Date: 27<sup>th</sup> October 2022  
Our Ref: P1320-2-0010

**Re: Hydrological & Hydrogeological Responses to An Bord Pleanála Further Information Request and Third-Party Submission in relation to the proposed Coole Wind Farm, Co. Westmeath (ABP Ref: 309770-21)**

Hydro-Environmental Services (HES) were requested by MKO Ireland (MKO) to respond to a further information request from An Bord Pleanála (ABP) with respect to geological, hydrological, and hydrogeological matters raised in relation to the proposed Coole Wind Farm SID application, Co. Westmeath.

Client:	MKO
Job:	COOLE WF, CO. WESTMEATH
Title:	DRAINAGE LAYOUT SHEET 6 OF 7
Figure No:	D106
Drawing No:	P1320-2-0221-A1-D106-00A
Sheet Size:	A1
Project No.:	P1320-2
Scale:	1:2,000 (A1)
Drawn By:	MG/GD
Date:	17/02/2021
Checked By:	MG

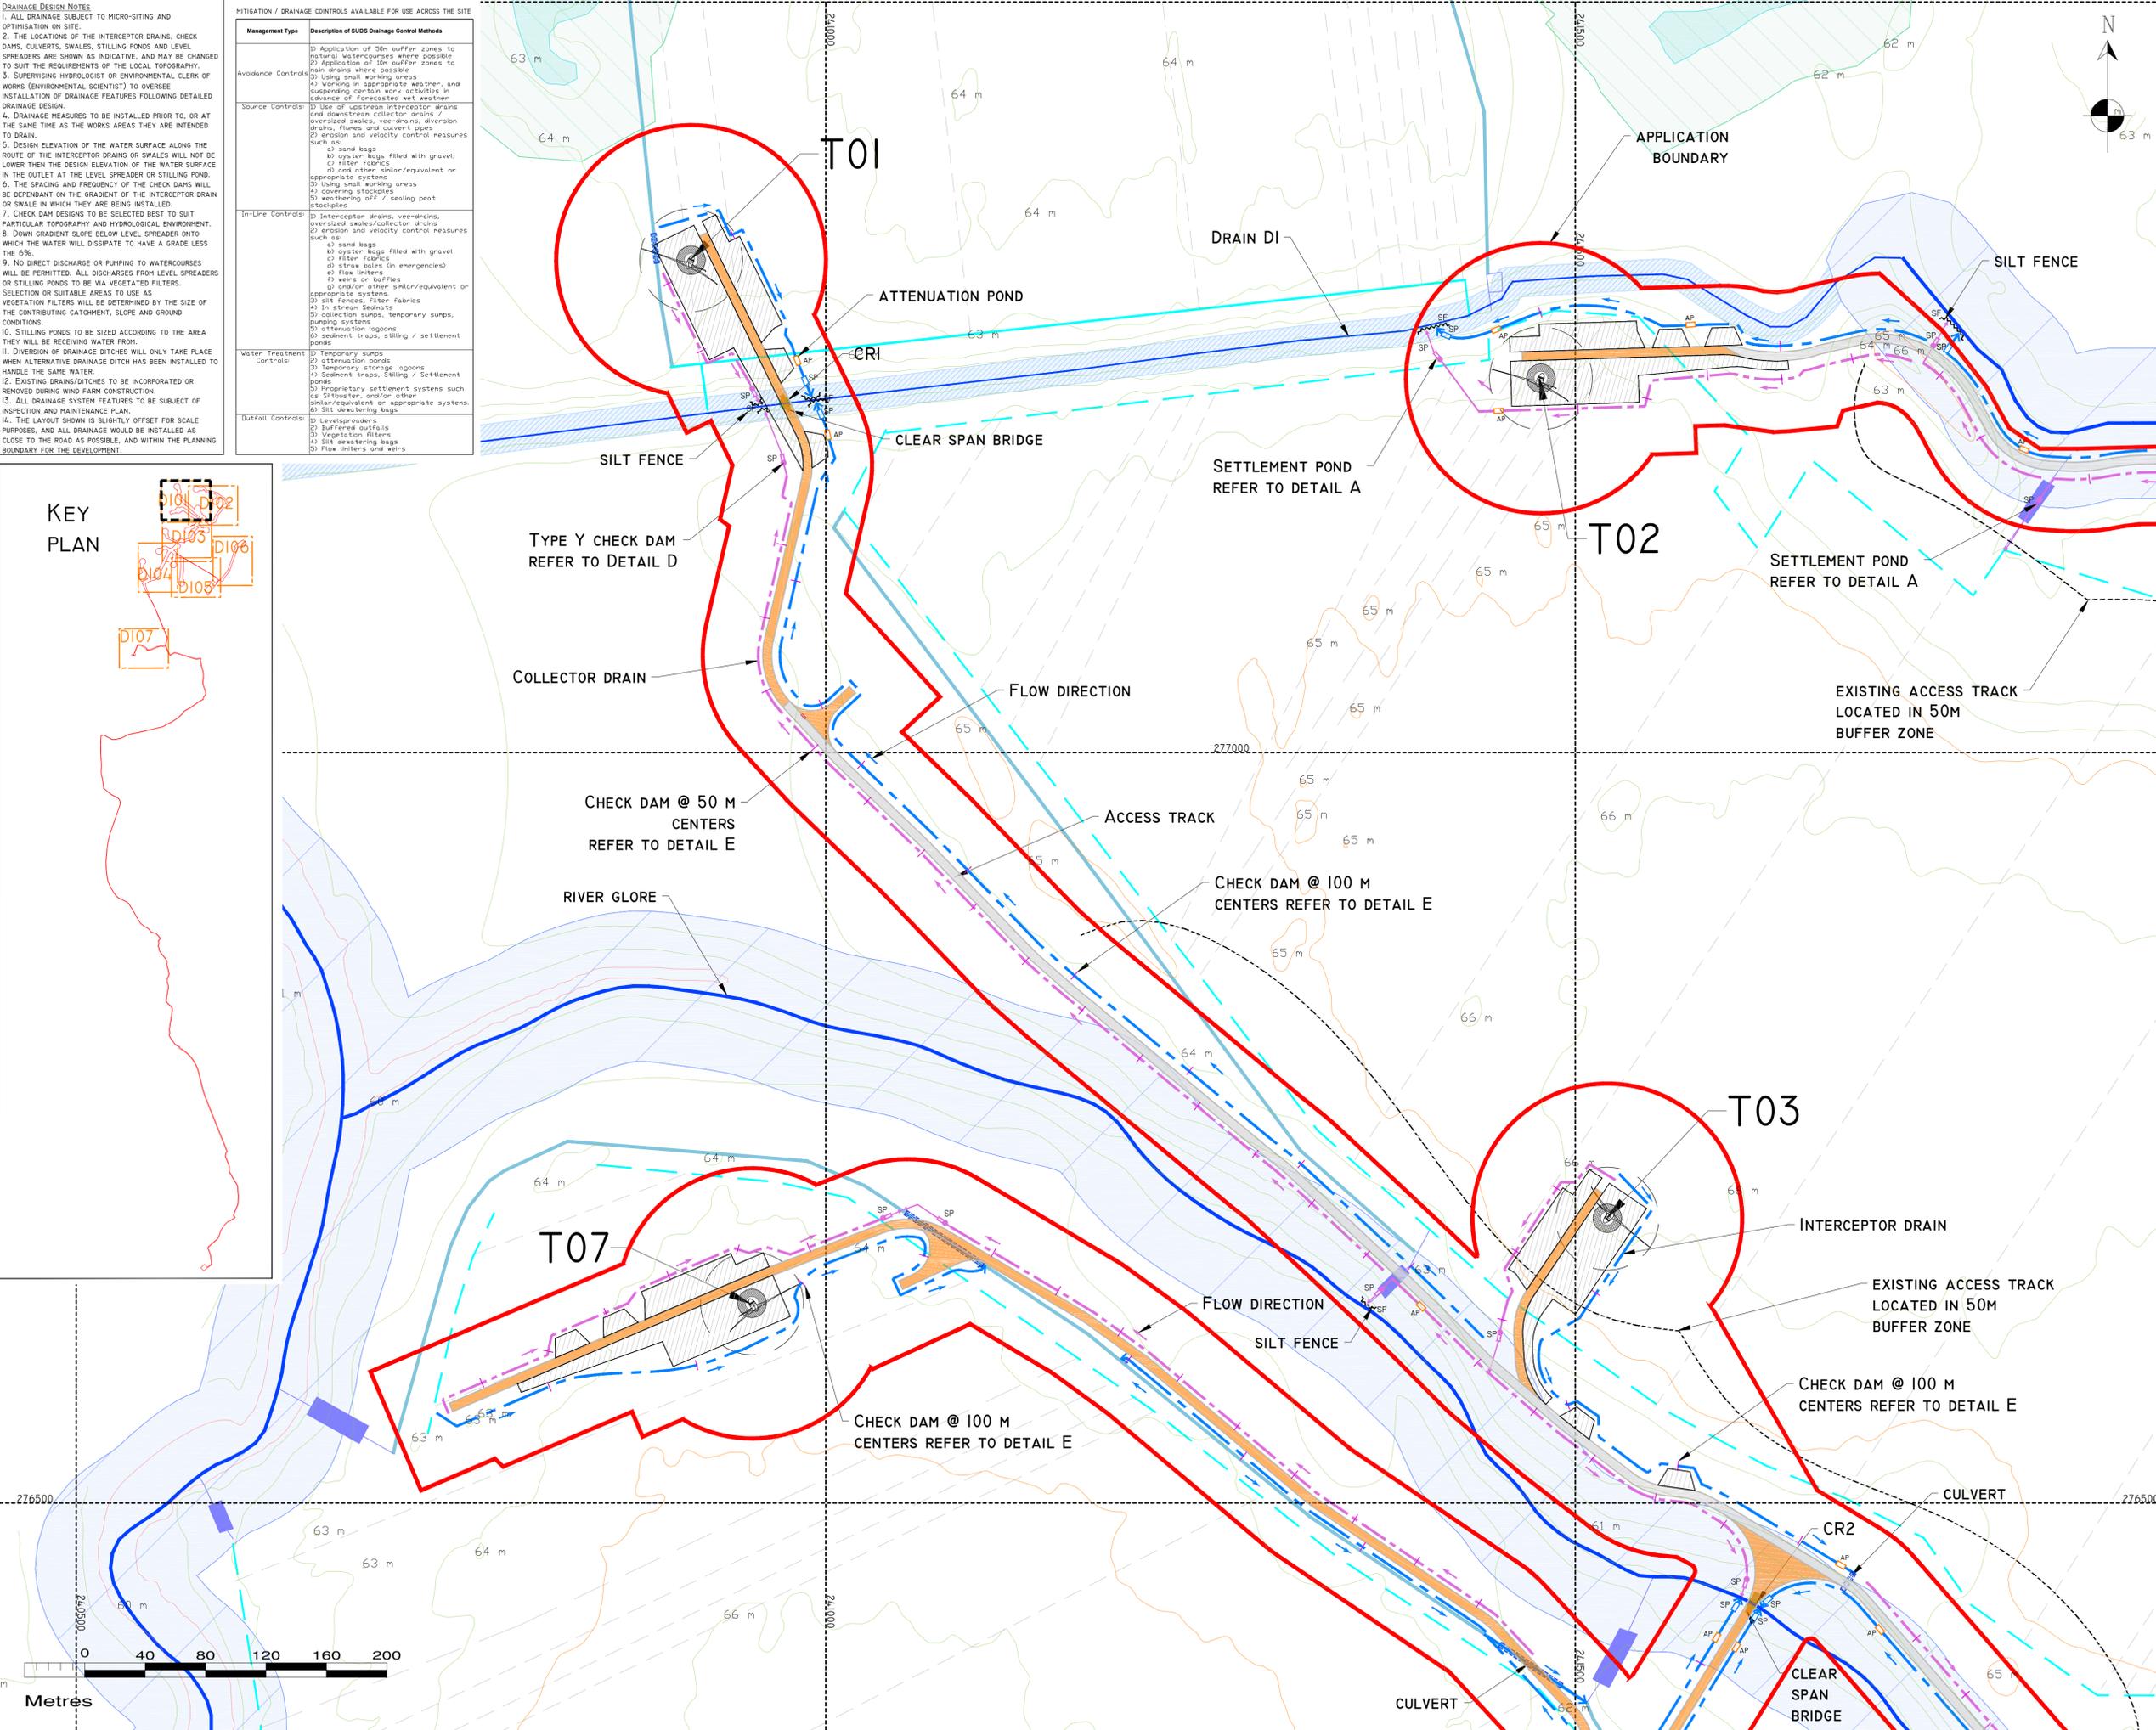
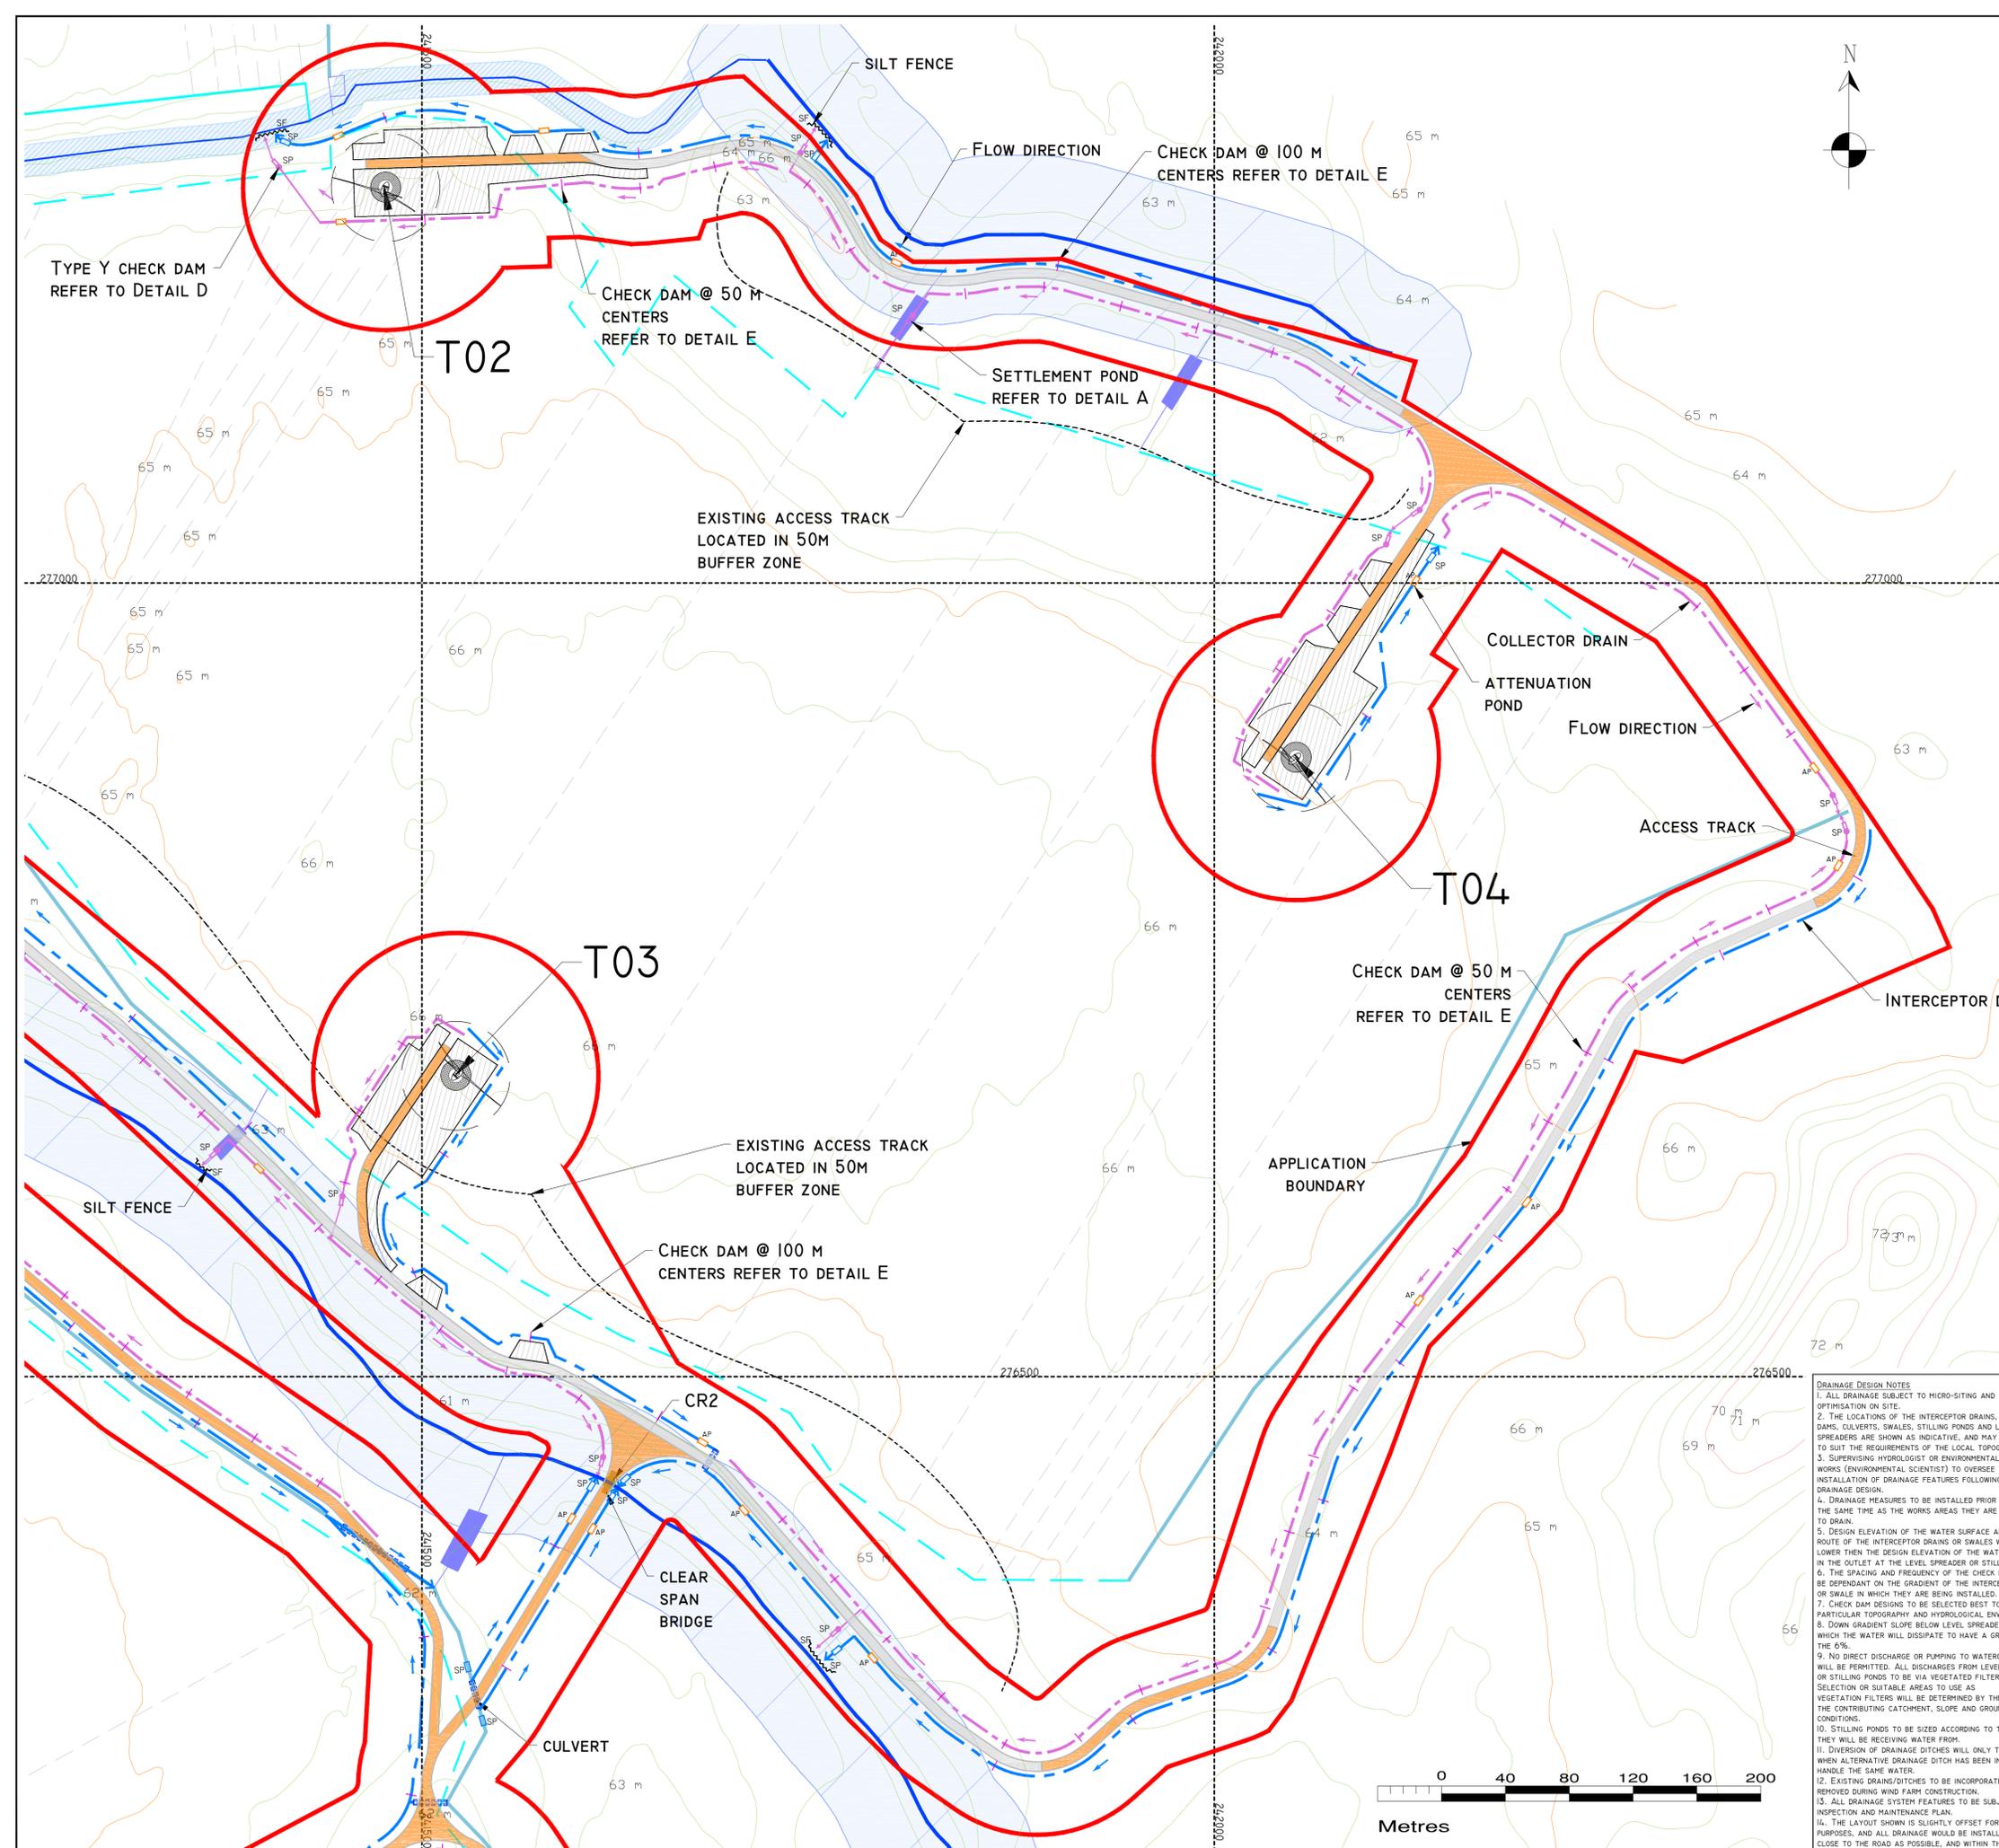
- b) The potential for impacts on Gariskil Bog and Scragh Bog as a result of the effects of drainage works.*
- c) The need to identify the location of all mitigation measures involved in the construction phase drainage management.*

*“You are requested to clarify the layout and management arrangements for the operational drainage structure.”*

The locations of proposed mitigation measures to be implemented within the Coole Wind Farm site during the construction phase including check dams, attenuation ponds, settlement ponds, silt fences, and collector and interceptor drains are shown in Drawings D101 to D107 (EIAR Appendix 4.9).

The drainage system as outlined in drawings D101-D107 (Refer to Appendix 4-9 and 9-3 of the EIAR) will be utilised and maintained during the operational phase of the proposed Wind Farm. The maintenance and management of the drainage system will be included within the overall maintenance regime of the Wind Farm.

- The inspection and maintenance of swales and settlement ponds;
- Inspecting cross-drains for any blockages, and removal of any blockages identified;
- Inspecting and maintaining outfalls to existing field drains;
- Inspecting the existing roadside drains for any obstructions, and removal of any obstructions identified;
- Inspecting the progress of the re-establishment of vegetation and where required testing the water quality at the outfalls periodically; and,
- Inspection and regular cleaning of drainage channels and settlement ponds. Drainage inspections and maintenance will be in completed accordance with CIRIA C697 SuDS and Maintenance Manual.
